**From:** Nigel Hunston  
**Sent:** 27 July 2016 15:57  
**To:** Louise Bearcroft  
**Subject:** 2016/92234 at location Unit 1 Kingsgate Centre, King Street, Huddersfield, HD1 2Q

Content	PROPOSED SHOPFRONT DETAIL			
Client	WD KINGS_GATE LTD			
Project	PROJECT TITLE			
Date	22.08.16	Drawing Scale	1:20 & 1:10@ A1, 1:40 & 1:20@A3	
Paper size	A1	Drawn by	AF	Checked HB
Project Code	846A	Drawing No.	PL-004	Revision -

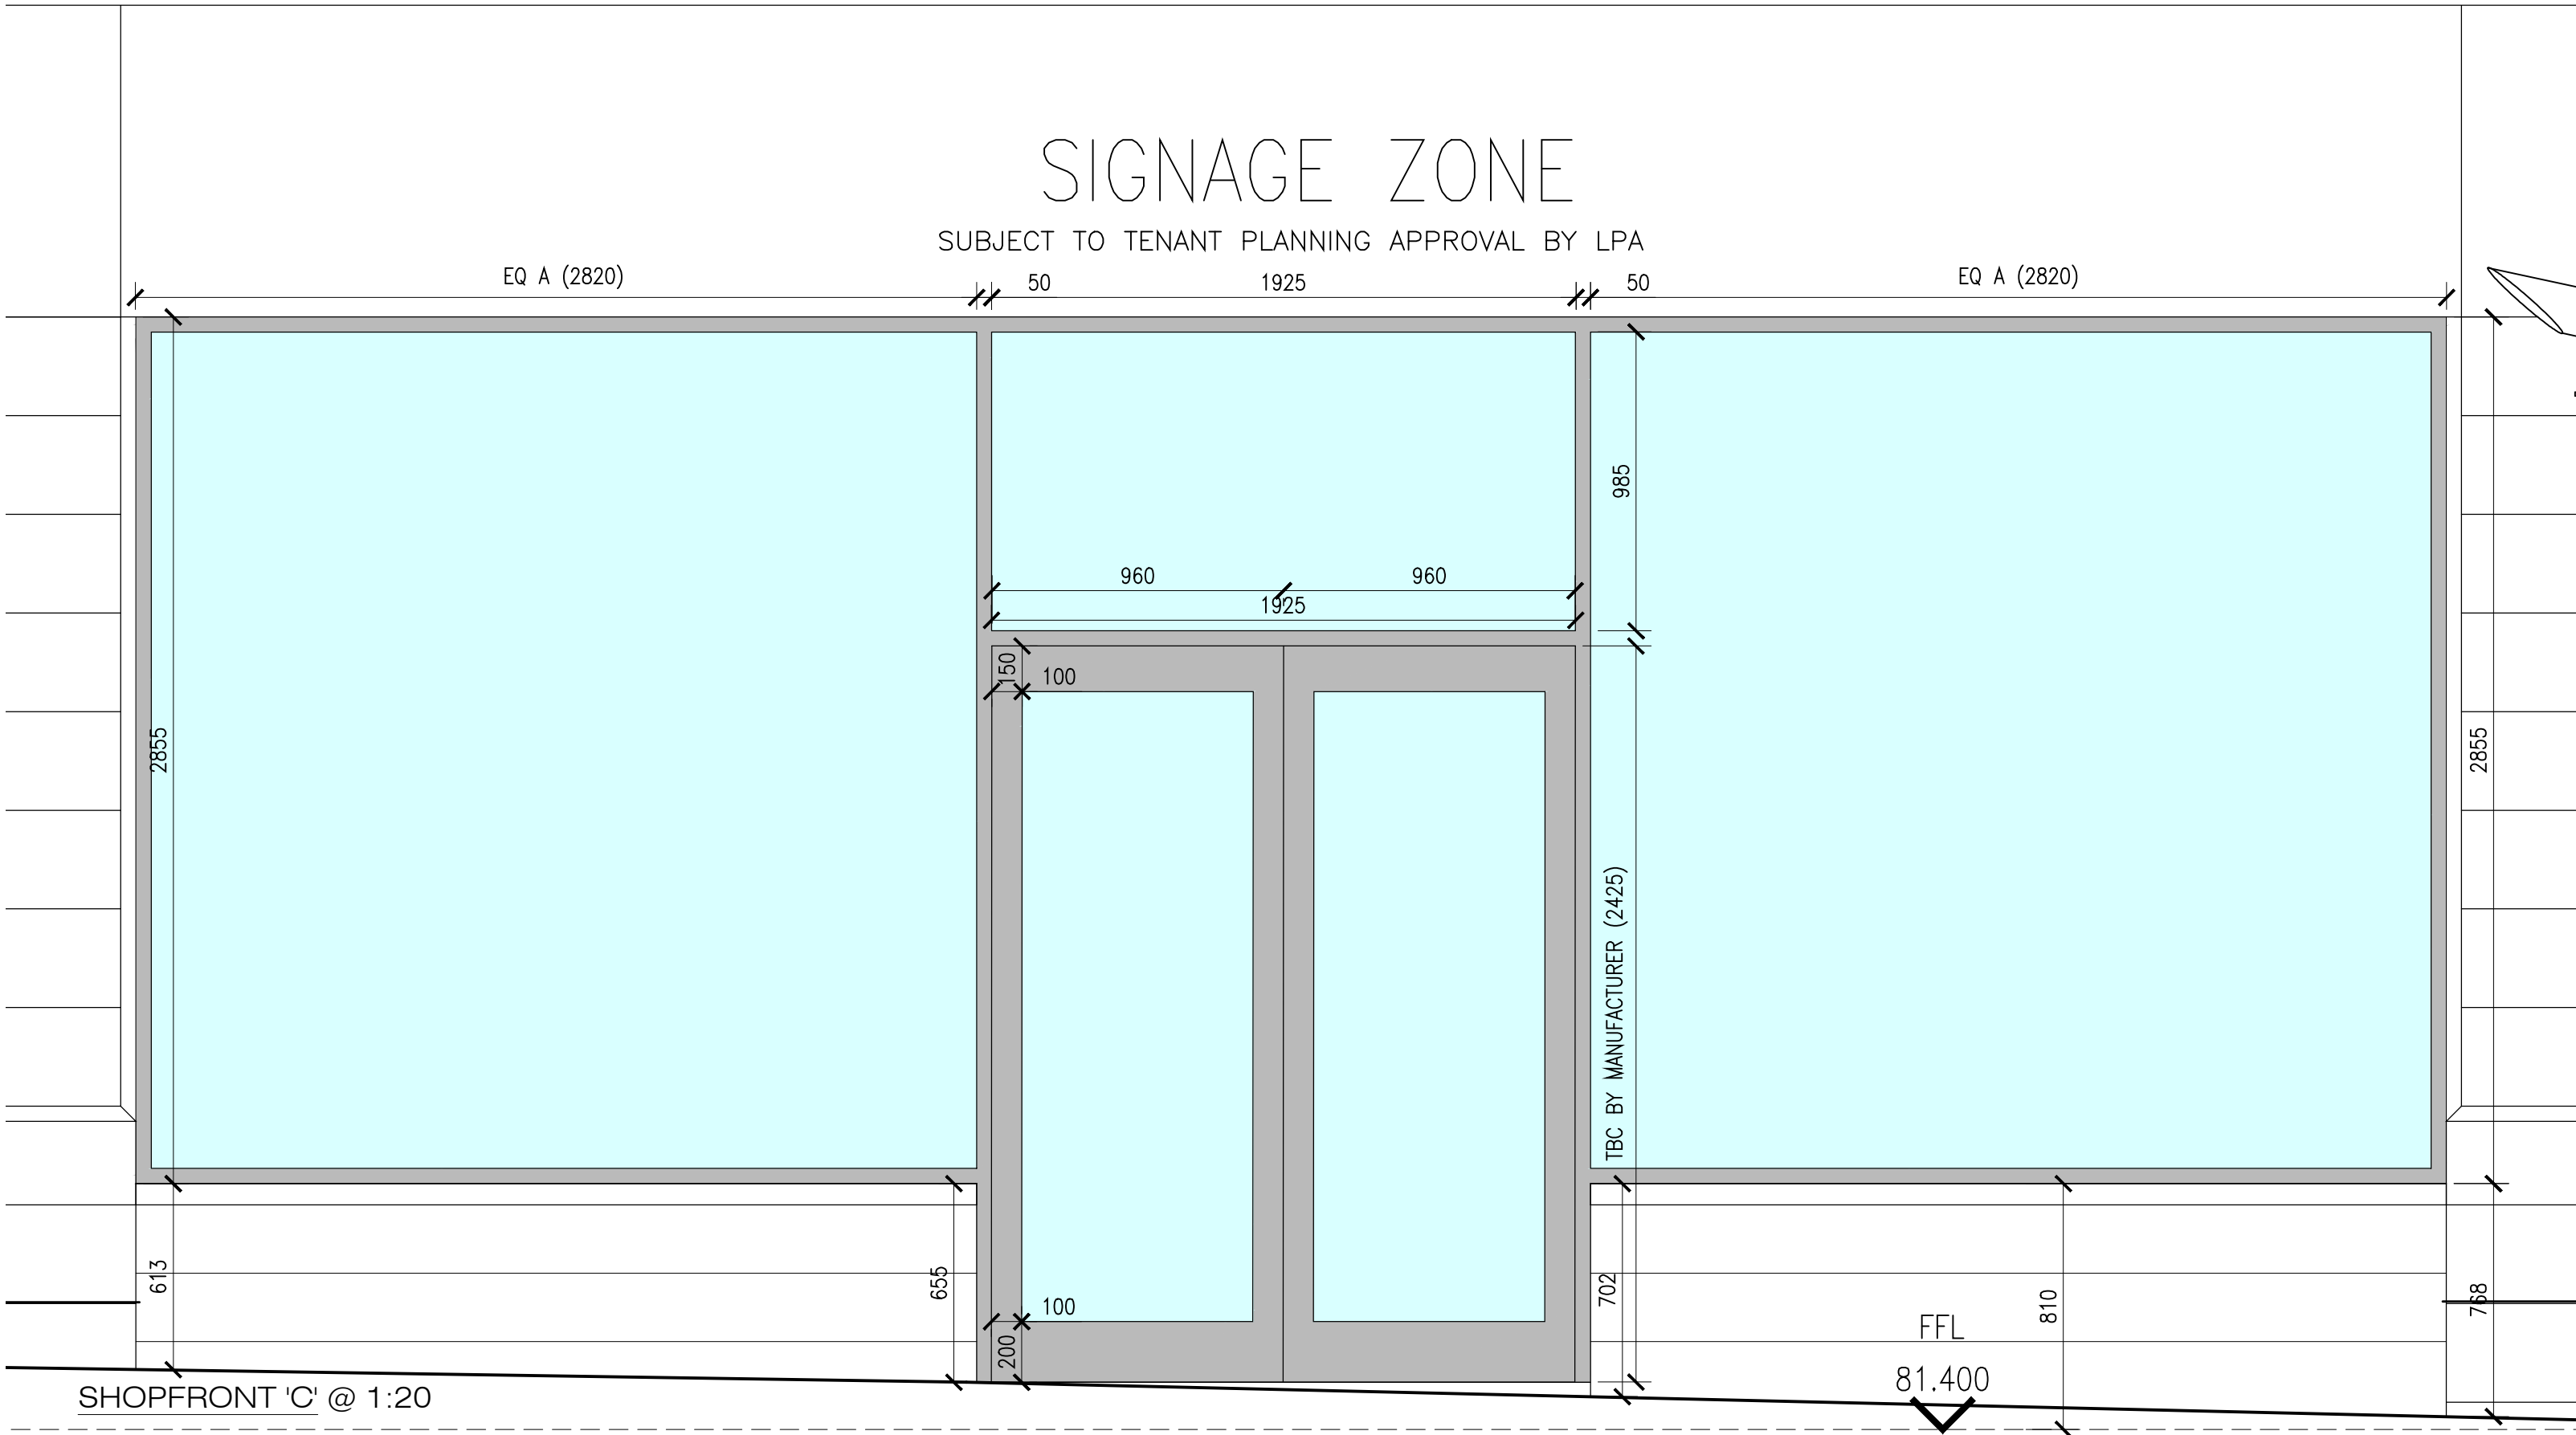
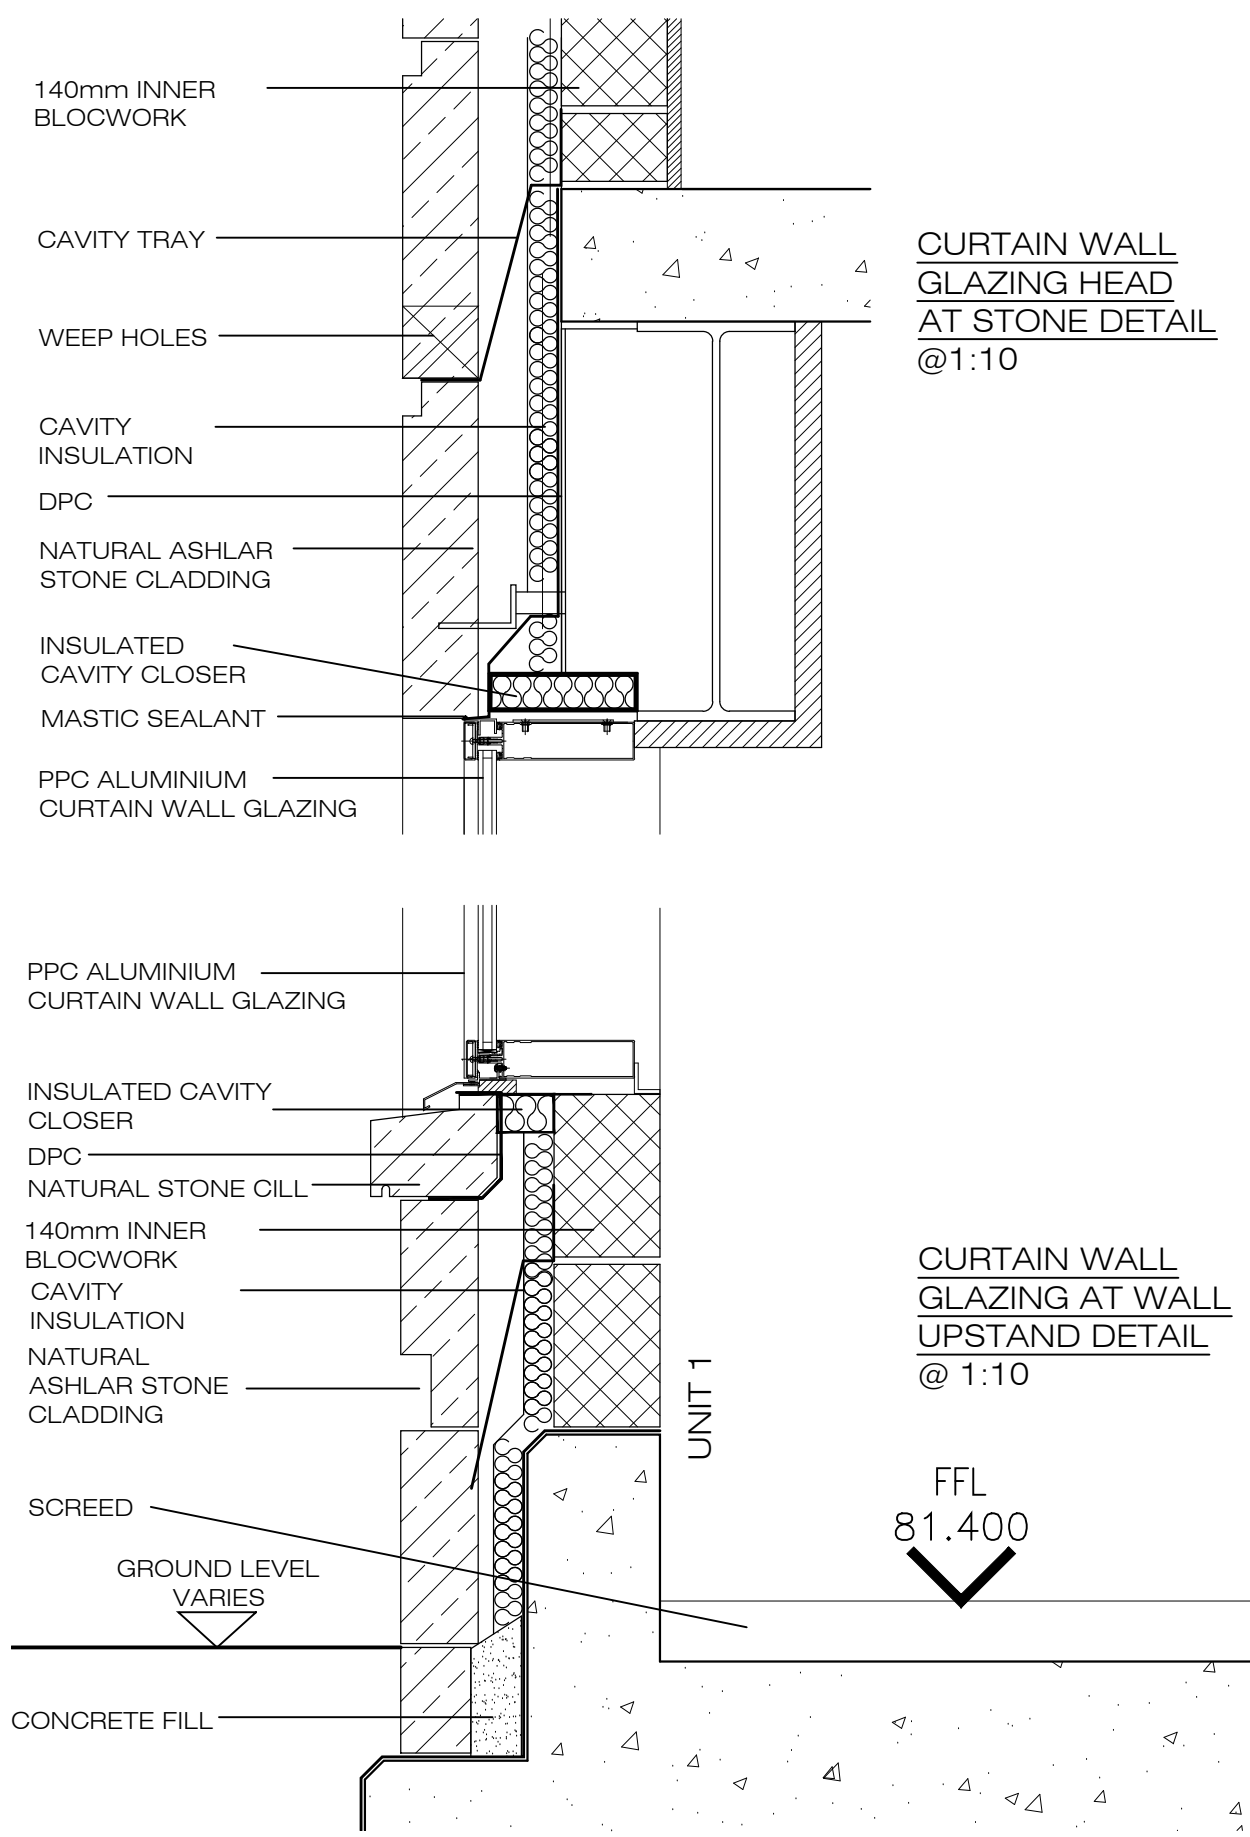
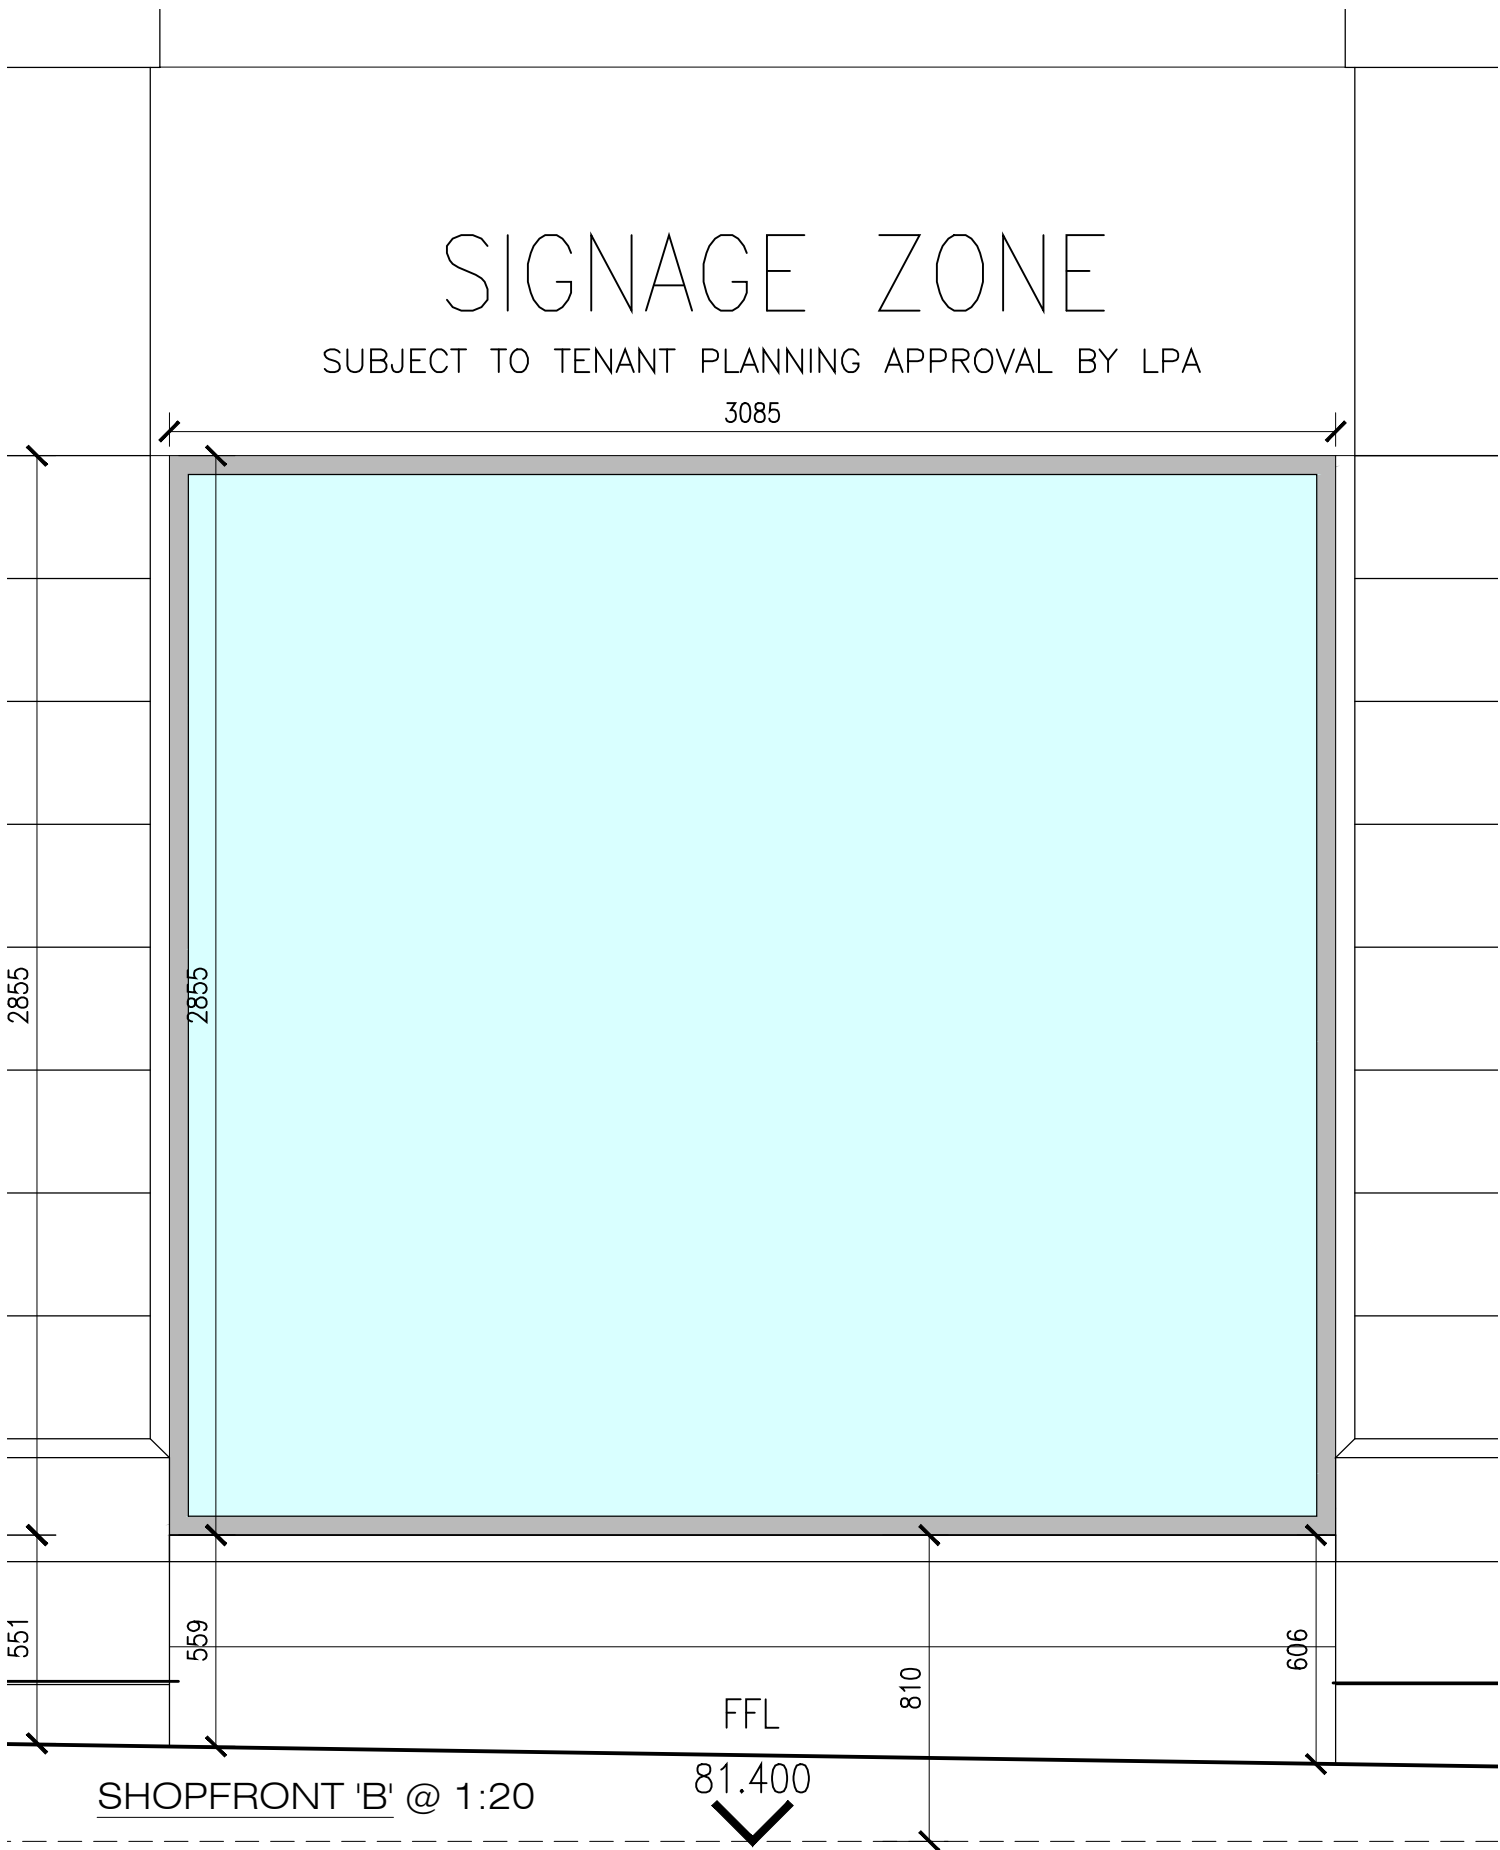
To assess the application fully, and whilst the elevations appear to show well-proportioned shop fronts, a drawing at 1:20 showing the detailing of the frame should be submitted.
